PRE-REGISTRATION CHECK SHEET – TO BE COMPLETED BY DUTY OFFICER AS APPROPRIATE

Application Ref: 24/00191/DPP Pre-application Ref: _____ Online App

<p>UPRN: 000120029346 (If NO UPRN – Admin to contact Technician)</p> <p>Site Address: <i>(Leave blank if no UPRN)</i> 160 MAIN STREET PATHHEAD EH37 5SG</p>	<p>Description of Proposal: Erection of two storey rear extension; installation of rooflights;; and replace roof material.</p>
---	---

DRAWING TITLE
Proposed plans

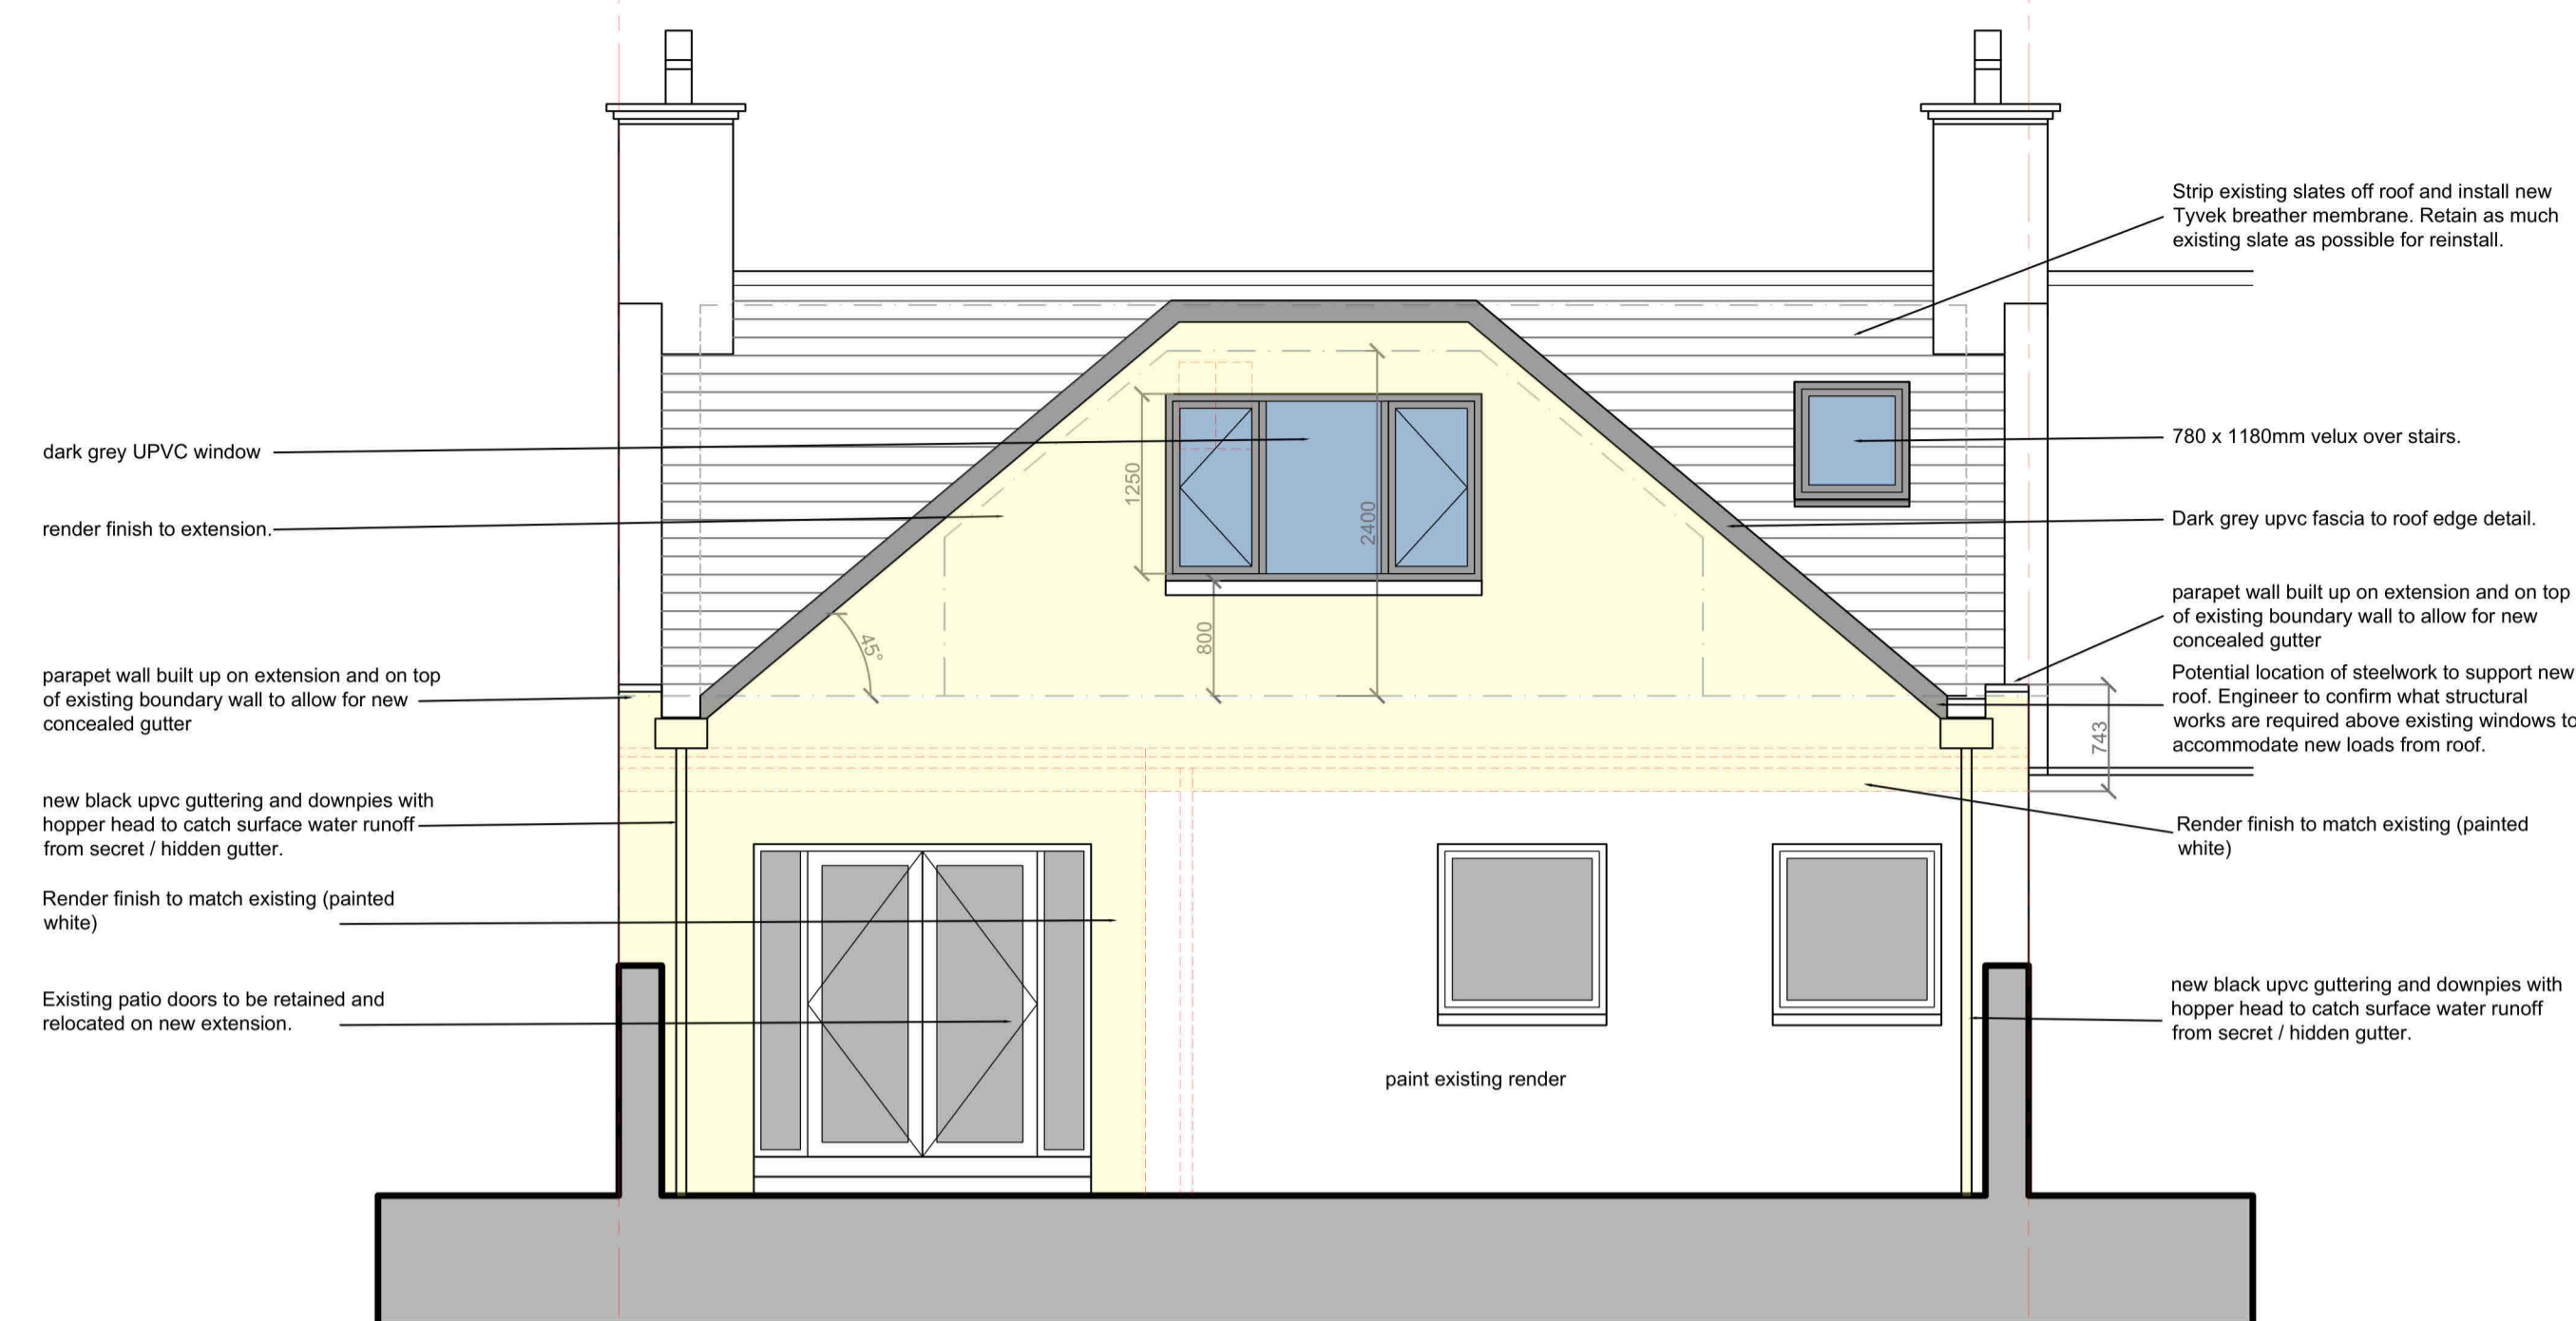
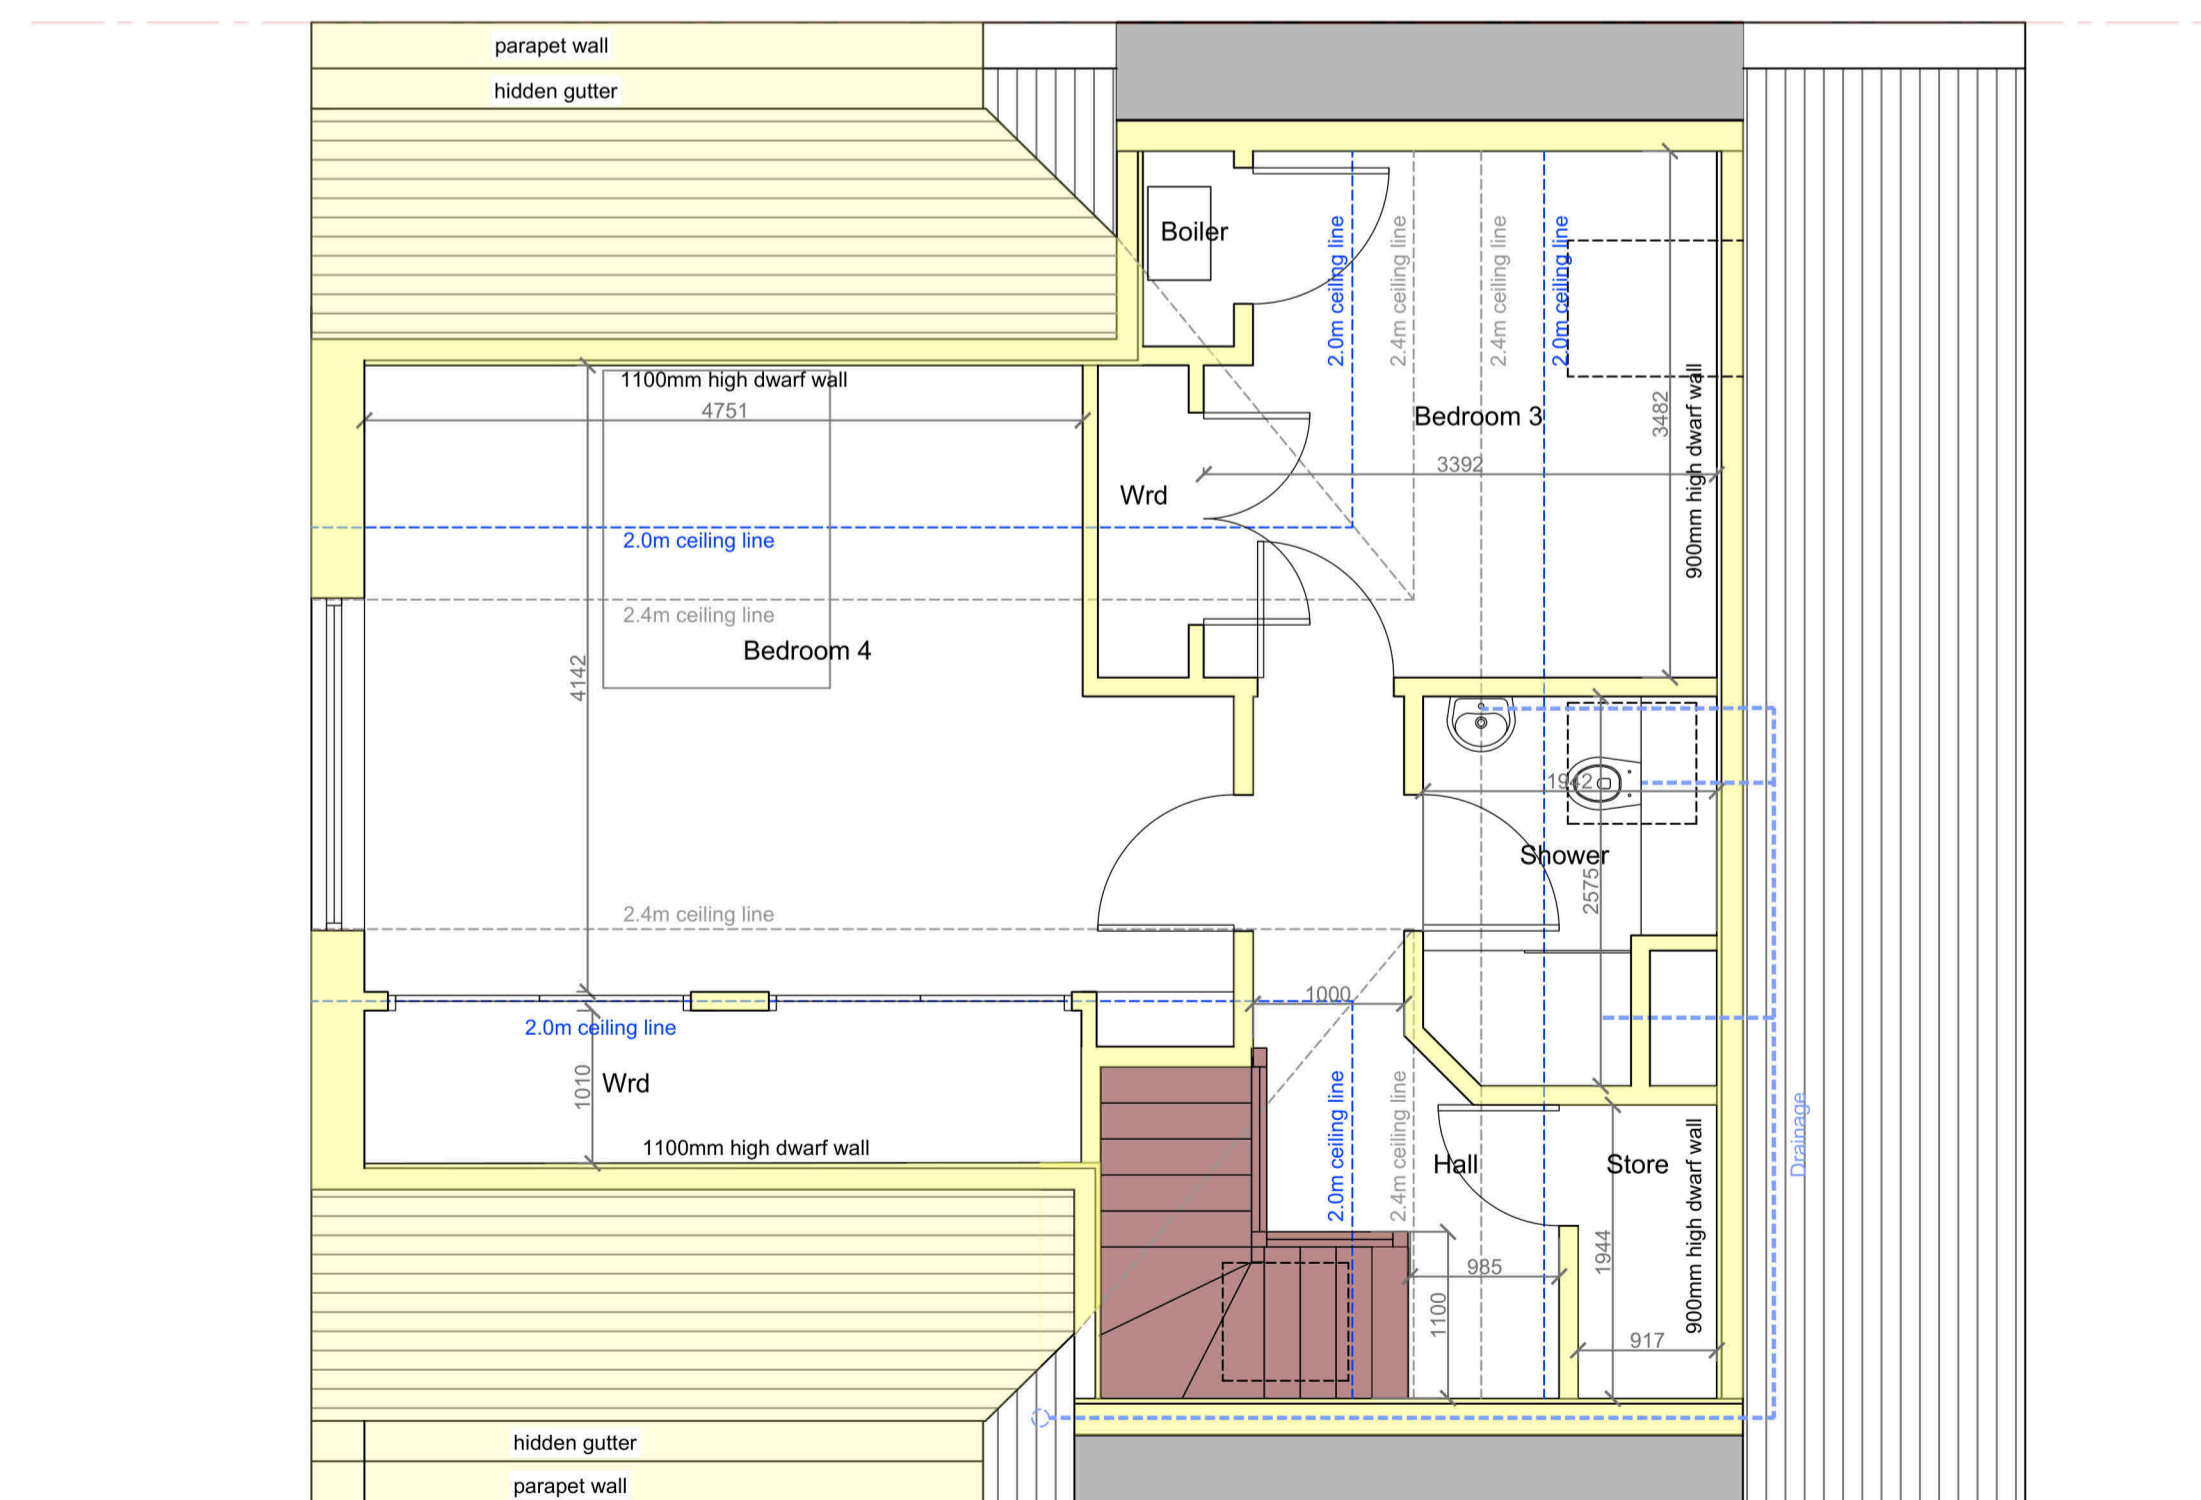
The rooflight being installed on the rear extension, as shown on the roof plan, is not shown on the proposed side elevation.
